**SOUTH DERBYSHIRE DISTRICT COUNCIL’S ANSWERS  
TO THE EXAMING AUTHORITY’S ISSUE SPECIFIC HEARING 1 ACTION POINTS**

**ANSWERS FOR DEADLINE 5**

Oaklands Farm Solar Farm NSIP

**PINS Reference: EN010122**

Drawing Title
**Works Plan
 Sheet 2**

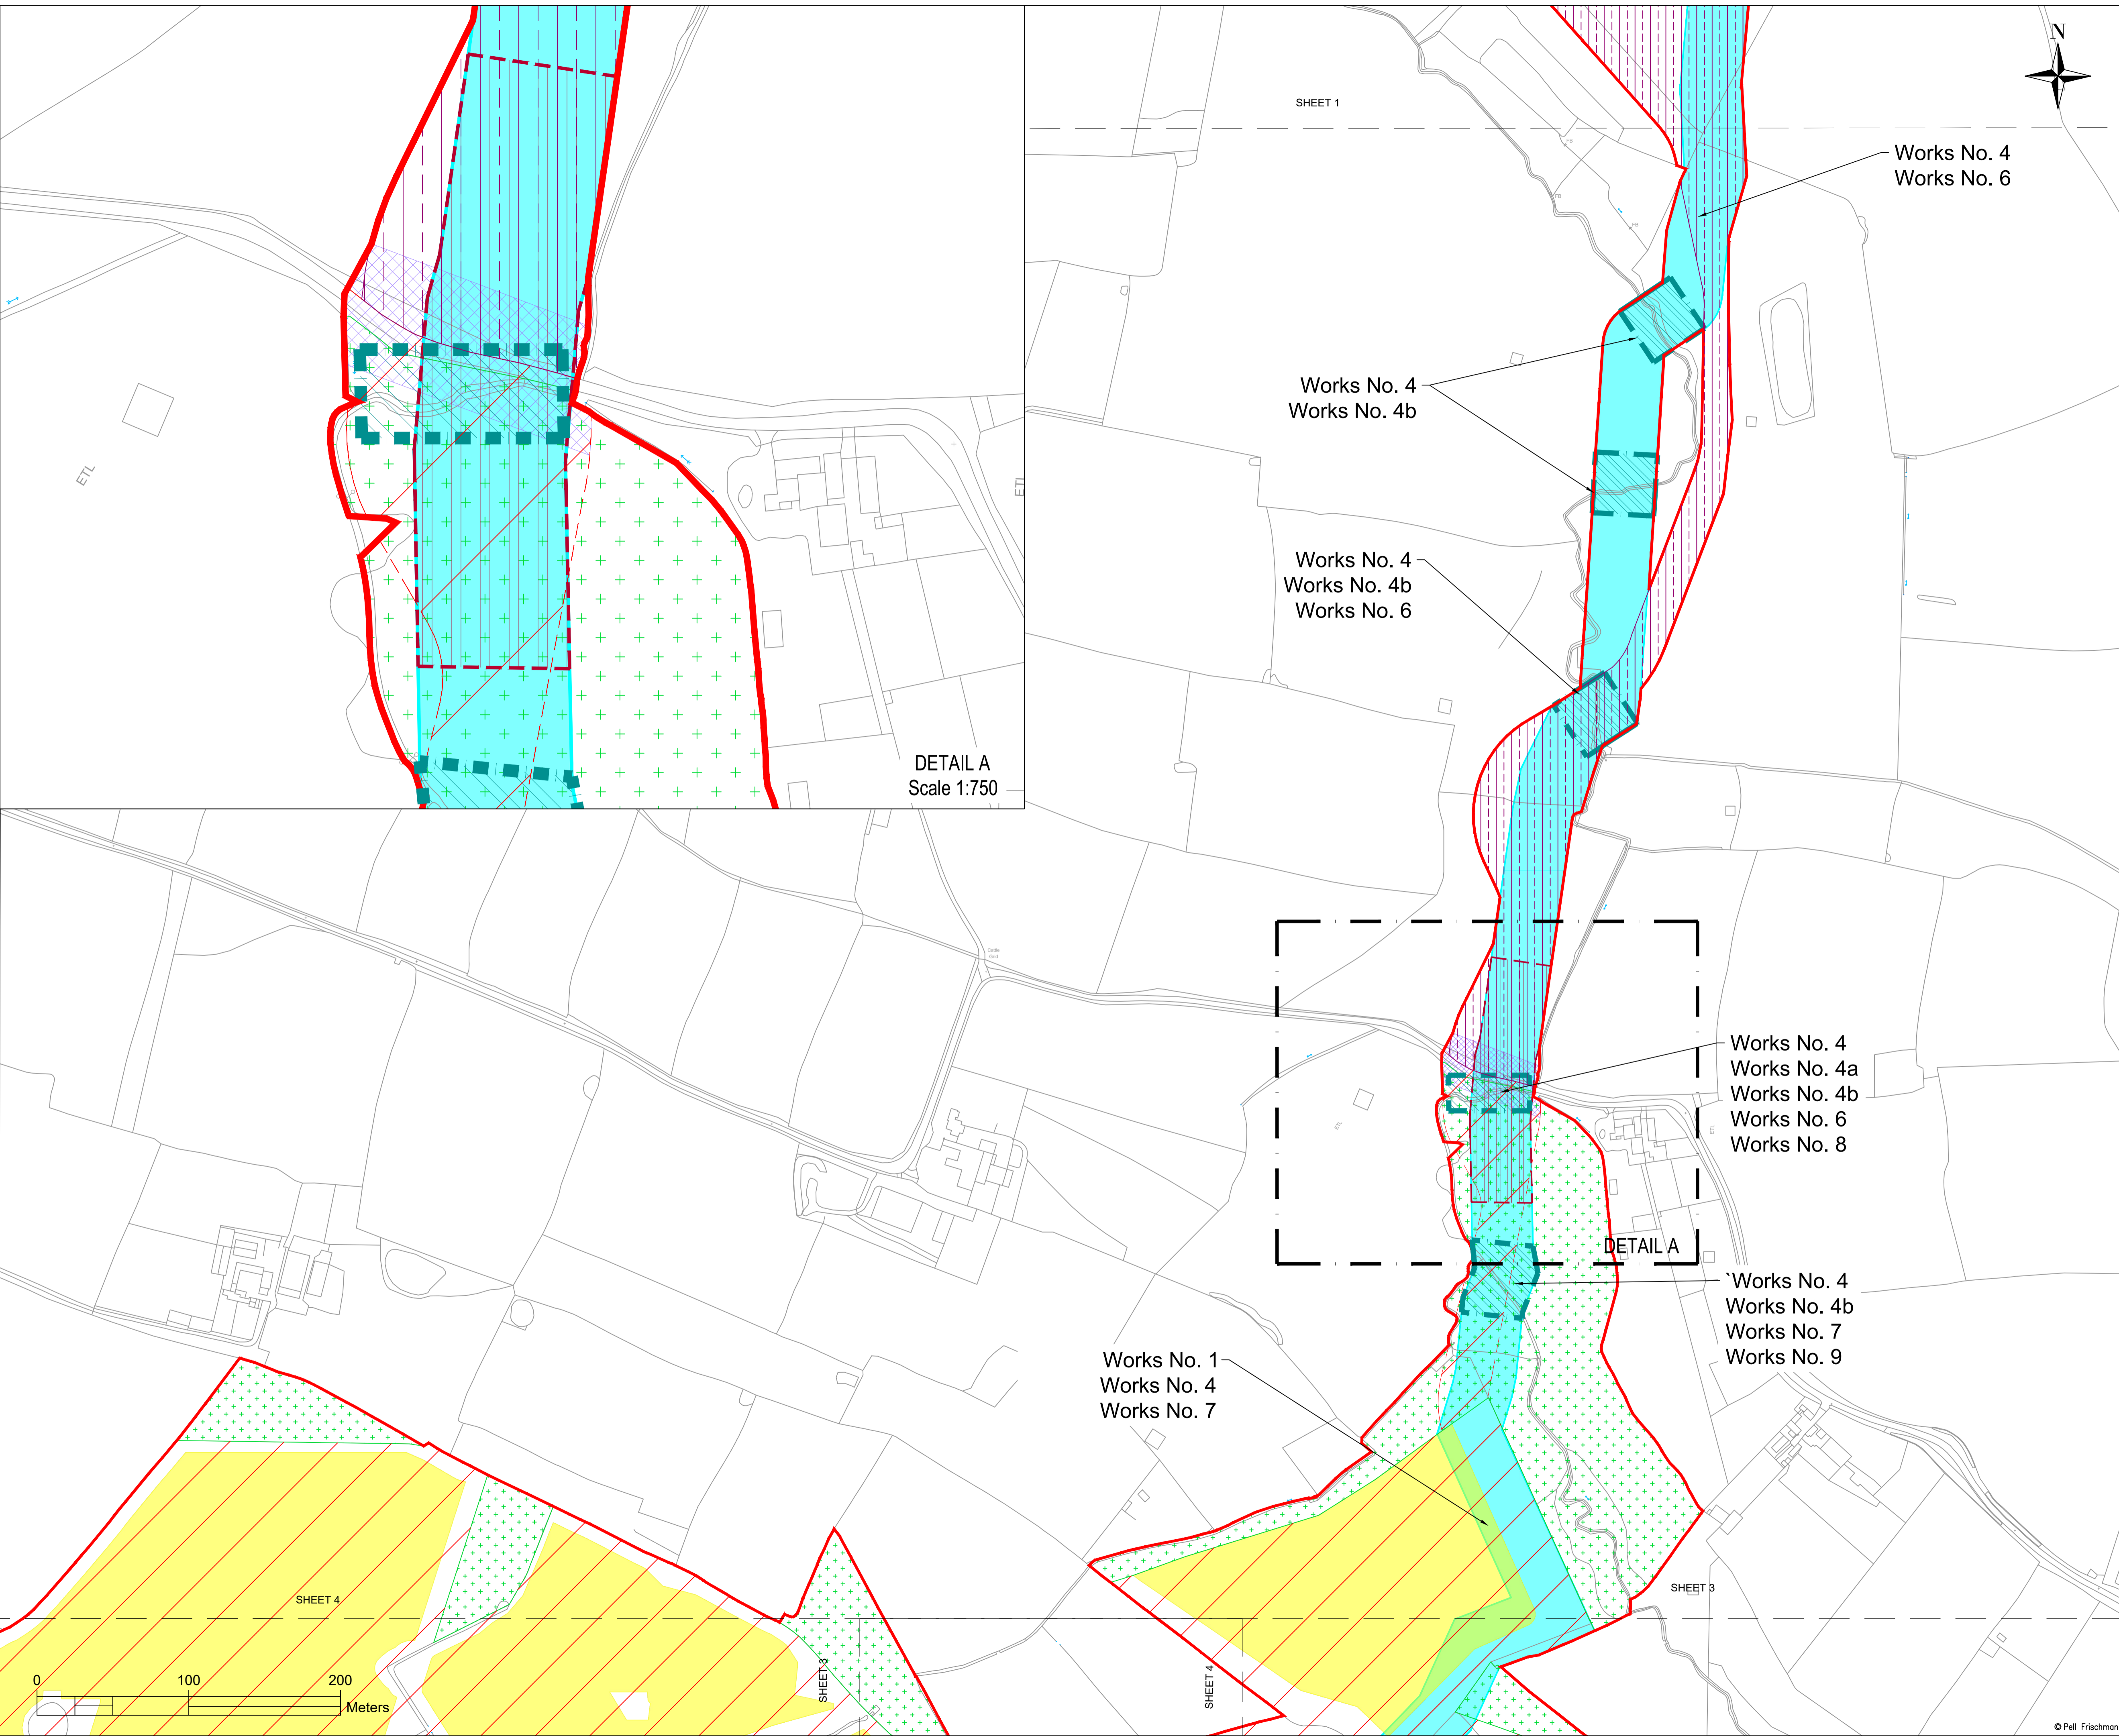
Item:	Action	SDDC Answer:
Other matters SDDC noted as Action Points not listed by the ExA		
a)	Clarification on areas of concern around the Haul Road.	<p>The submitted Works Plan from Pell Frischman reference Sheet 2, Drawing number SK02 (Examination Library ref APP-007) shows the route of proposed haul road. The HSE recommends that haul roads should be three and a half time the width of the widest vehicle using them, in this case HGVs.</p> <p>The ‘Site Works Plan’ Sheet 2, ref: SK02 shows that areas between works areas 4 and 6 will be directly affected by the proposed haul road, that will cut a swath through the valley bottom, dissecting and disconnecting areas of dense and mature vegetation and habitat, cutting across the watercourse, in locations where there are known to be otters, barn owls and bats. Further, works 4 and 4b will cut across the water course three times, through dense and mature habitat, with attendant clearance and disturbance that will radically alter the tranquil and bucolic appearance of the landscape in this location.</p>
